From: Sue Howell
Sent: 16 October 2017 10:48
To: Michael Eastham
Subject: RE: Amended site layout - the Lillies Caravan park site, Yapton Road, Barnham

Subject: Amended site layout - the Lillies Caravan park site, Yapton Road, Barnham

Flat Block A
Floor Plans & Elevations
Plots 19-24

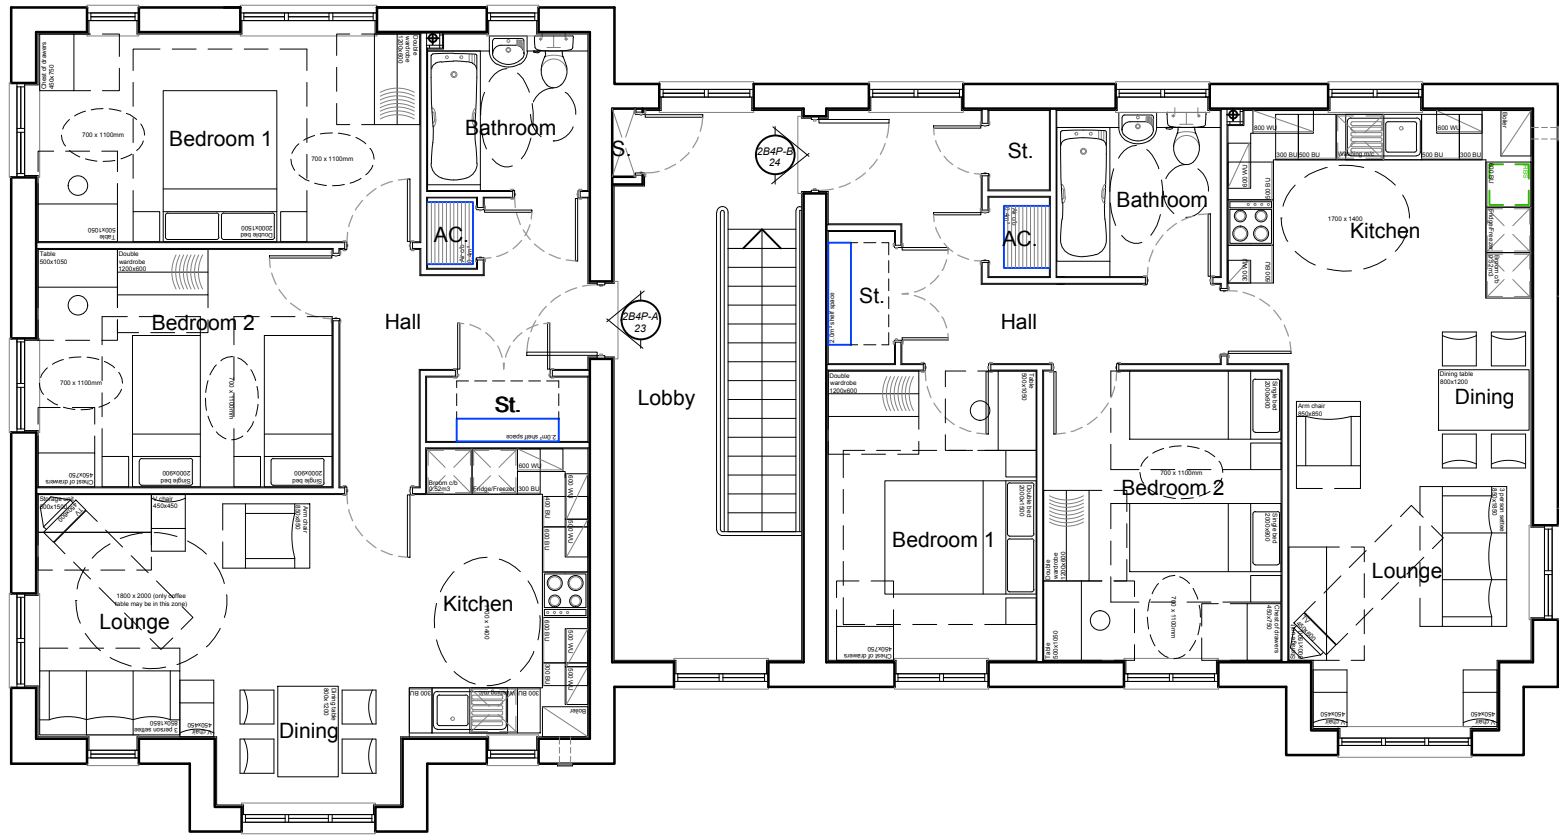
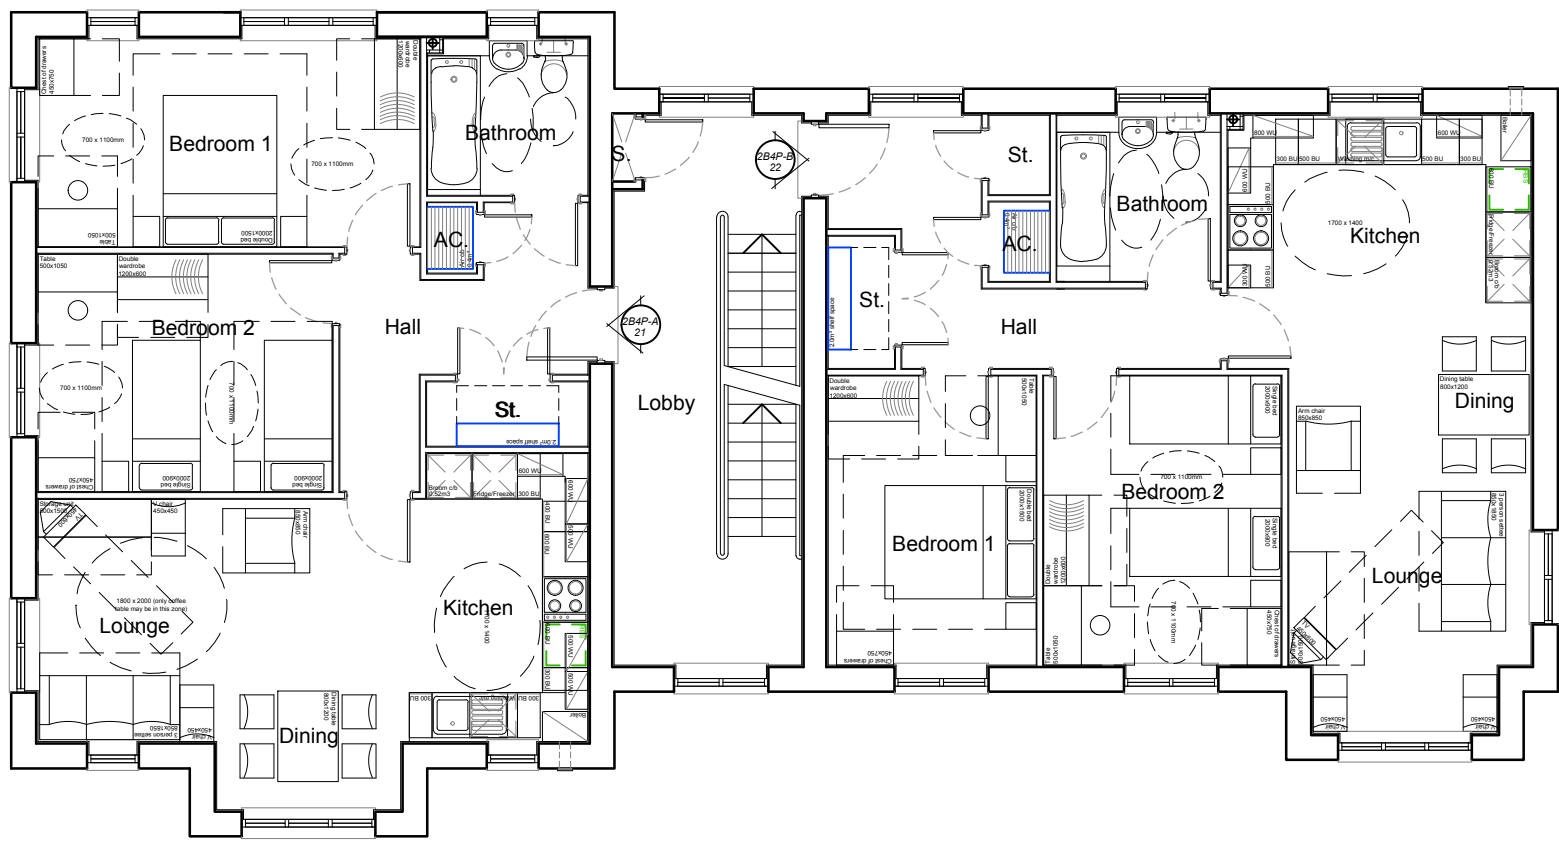
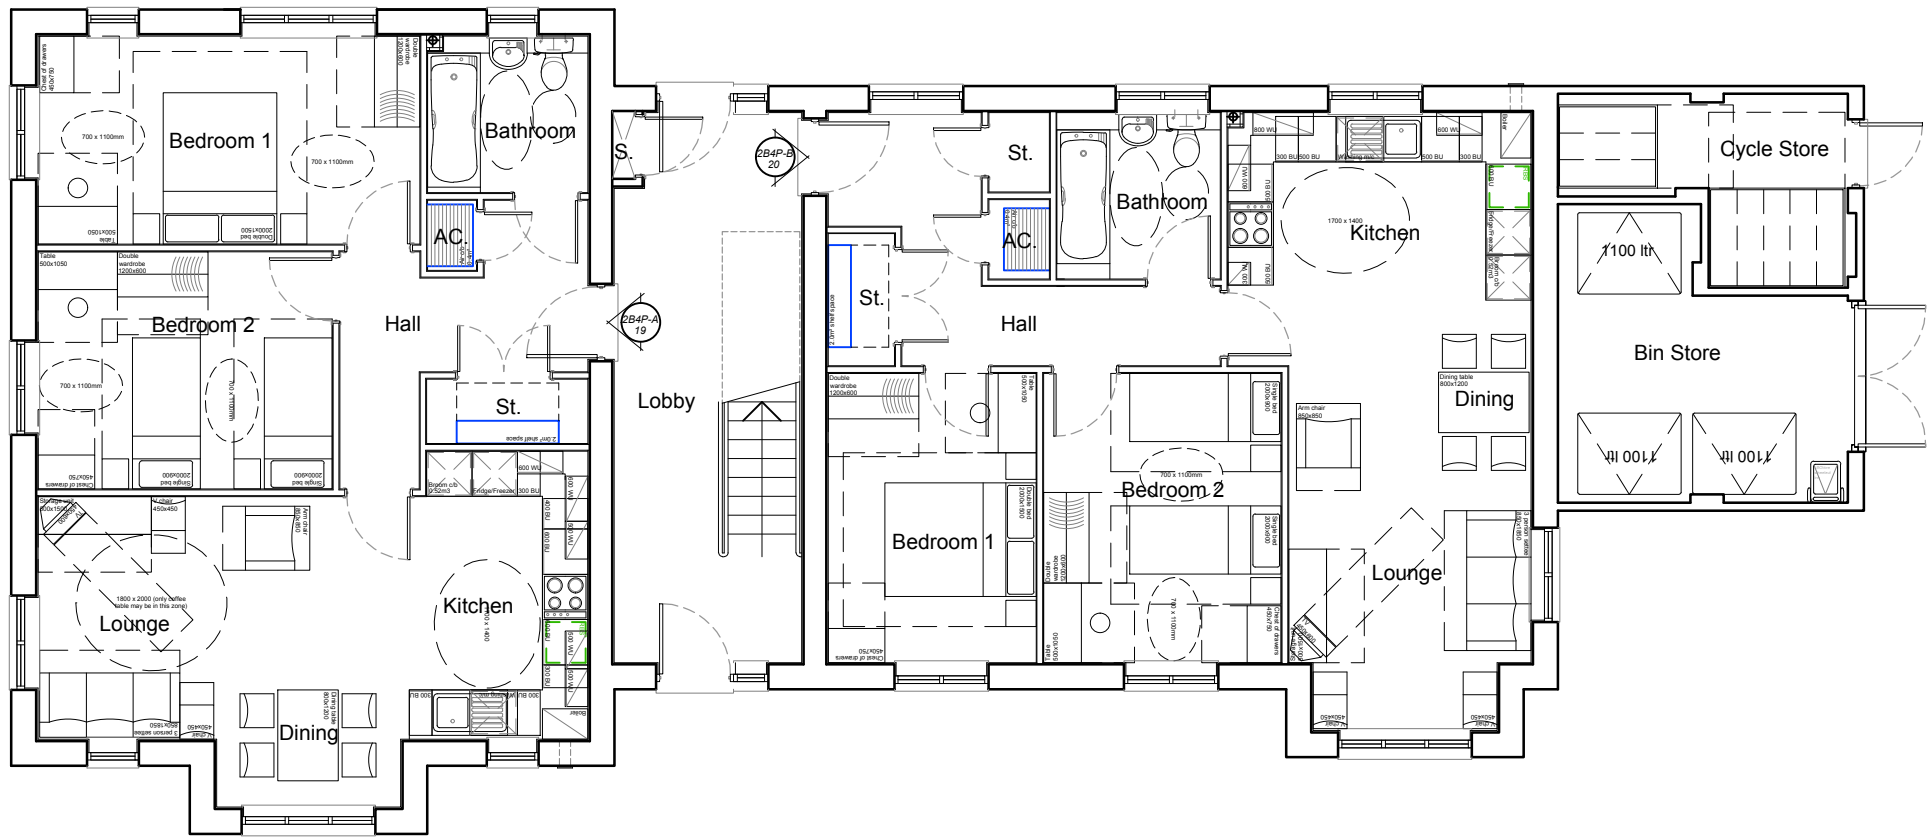
The now indicated attenuation basin to the centre of the POS is also of concern and would require clarification of whether this will be a standing water body? And what element of the year this will be the case? This area only depletes the POS as it would then not be classed as usable POS? and my concern also is regarding proximity of this in relation to Flat Block A 19-24 which should be raised and addressed.
